# **KITITAS COUNTY**

### **MEMORANDUM**

TO: Community Development Services  
FROM: Public Works Planning Review Team  
DATE: April 26, 2021  
SUBJECT: SE-21-00005 Ahlers

#### **SEPA Application Comments**

RECORD OF SURVEY
KITITAS COUNTY TAX PARCEL NO. 080836
LOT 4, GRM SHORT PLAT NO. 1
FOR
JOHN & LYNN AHLERS

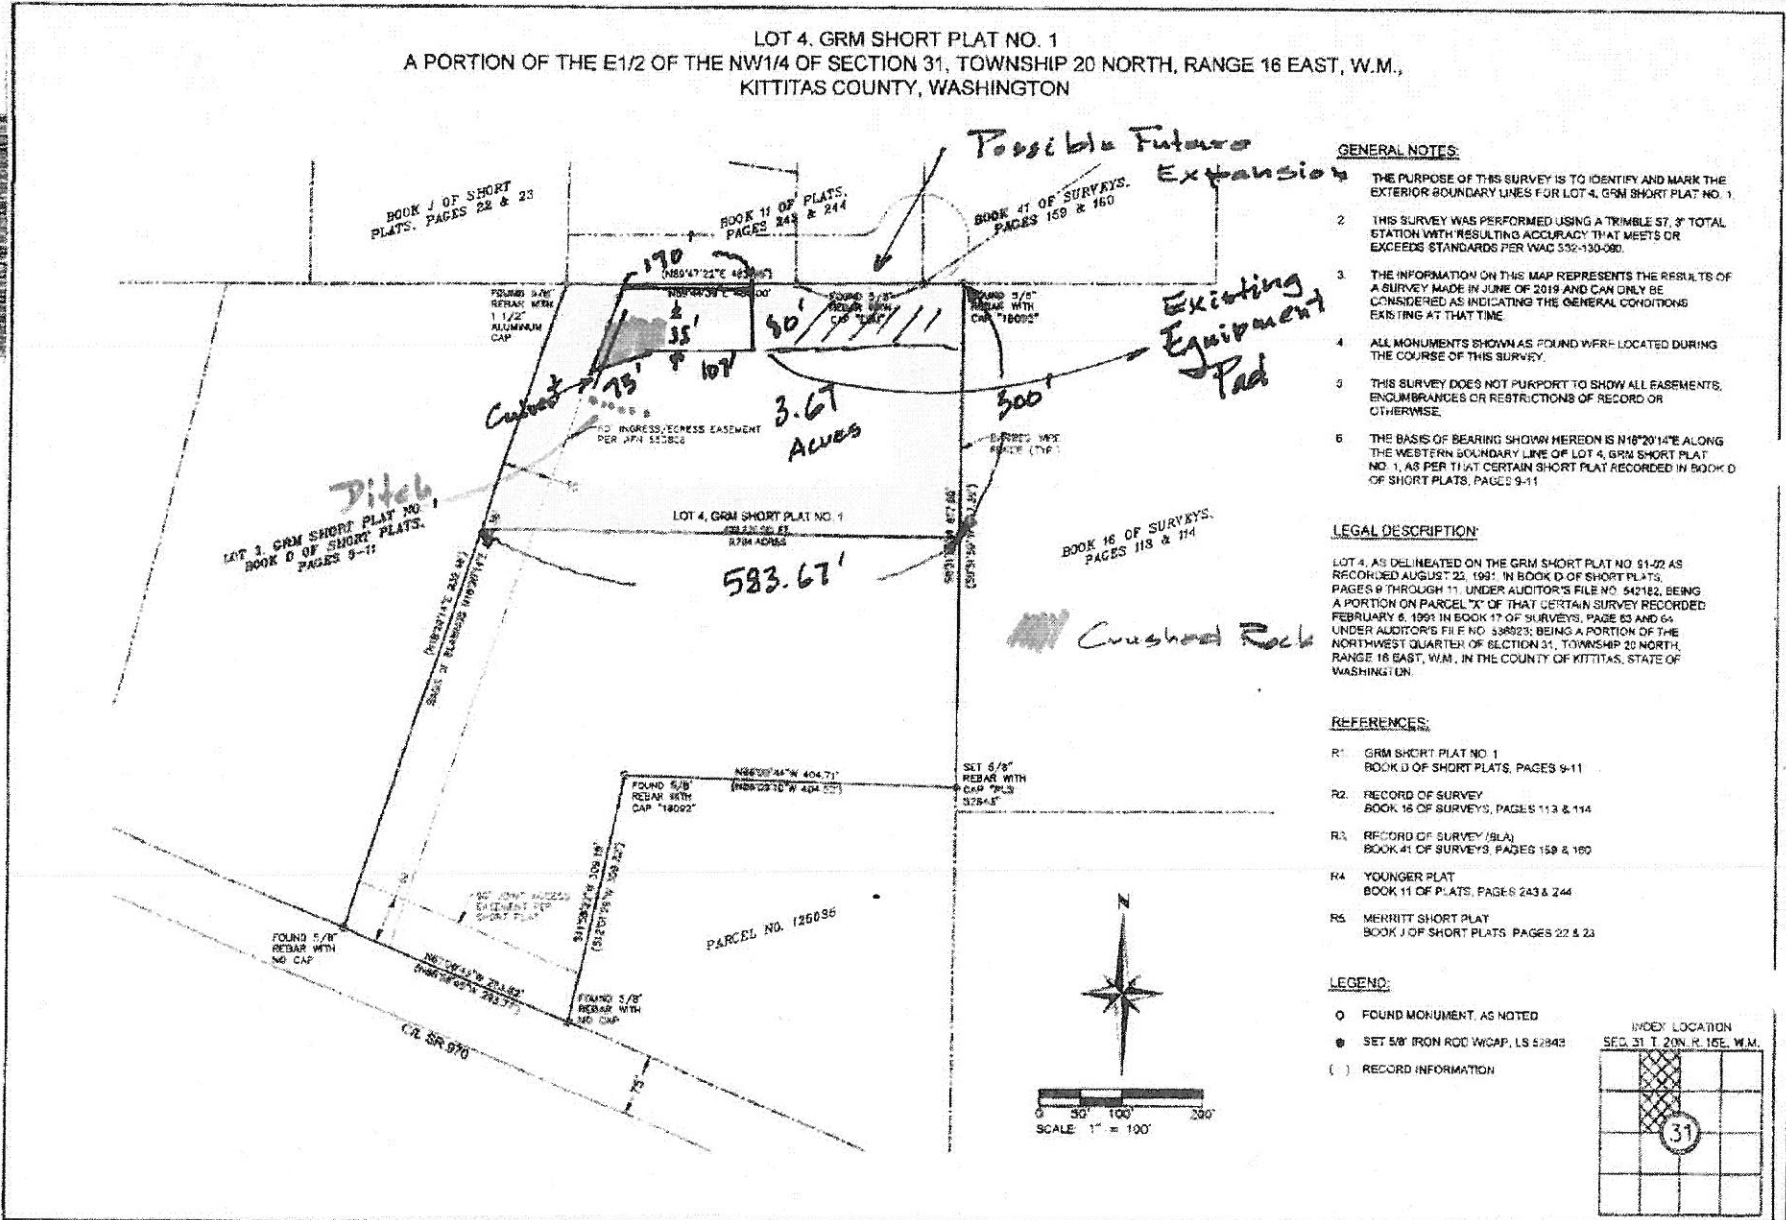
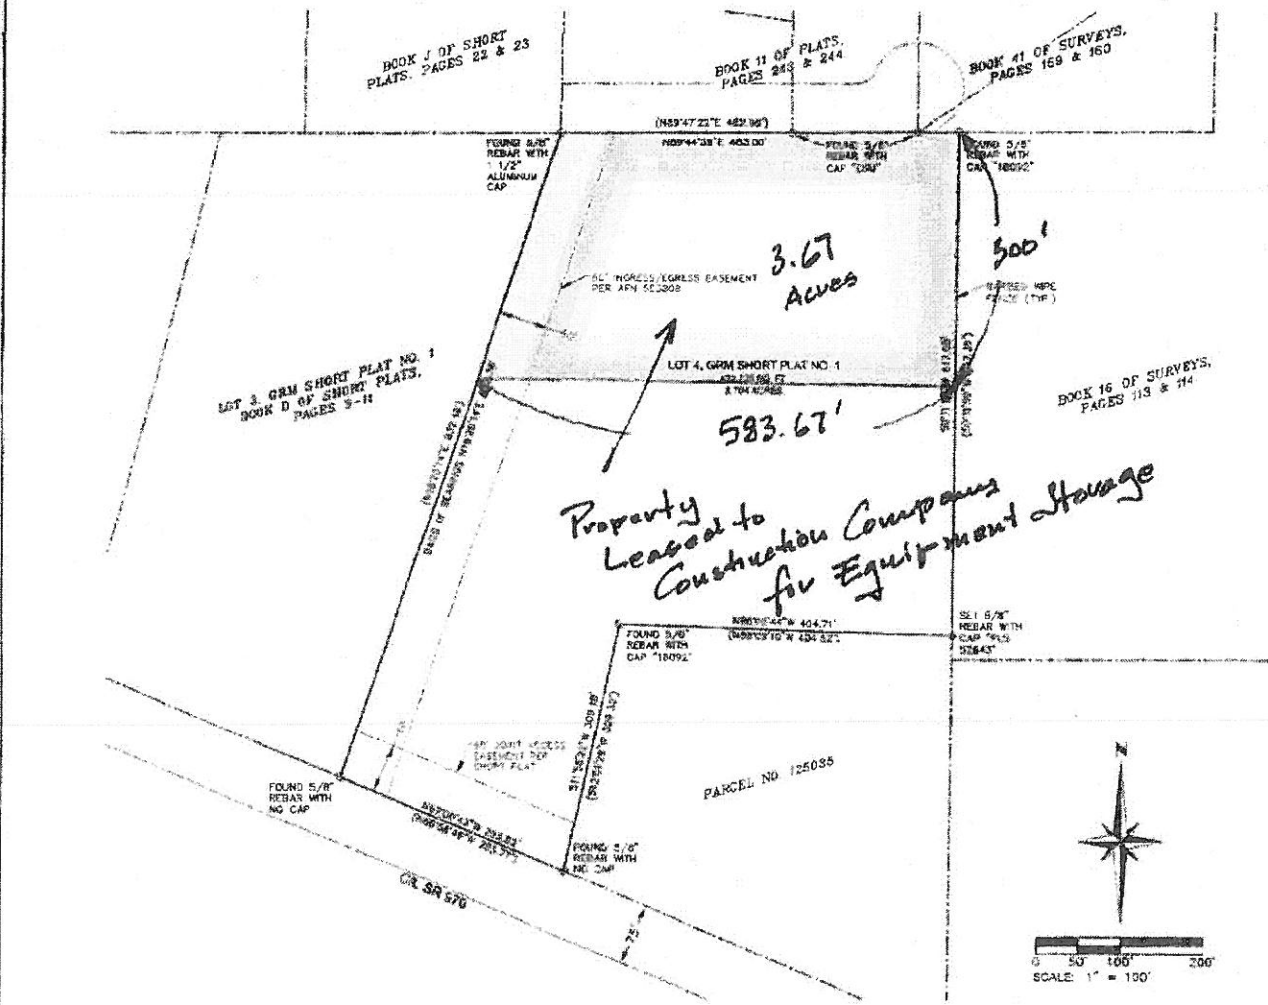
- Within the environmental section of the SEPA Checklist question 1e, the applicant listed quantities of 640 CY for cut and fill. The grading permit which the applicant obtained through Public Works lists different quantities on the initial permit and the plan set which was submitted. Please verify that the listed value is correct.
- Any grading over 100 cubic yards of material requires a grading permit. Any grading over 500 cubic yards of material will require engineered grading and storm water plans. See Kittitas County Code chapter 14.05.
- An access/address permit would be required prior to any building permit being issued.
- The proposed project is within the FEMA identified floodplain and the applicant has applied for a floodplain development permit. As required by KCC 14.08.315, compensatory storage will be required for fill placed within the floodplain.
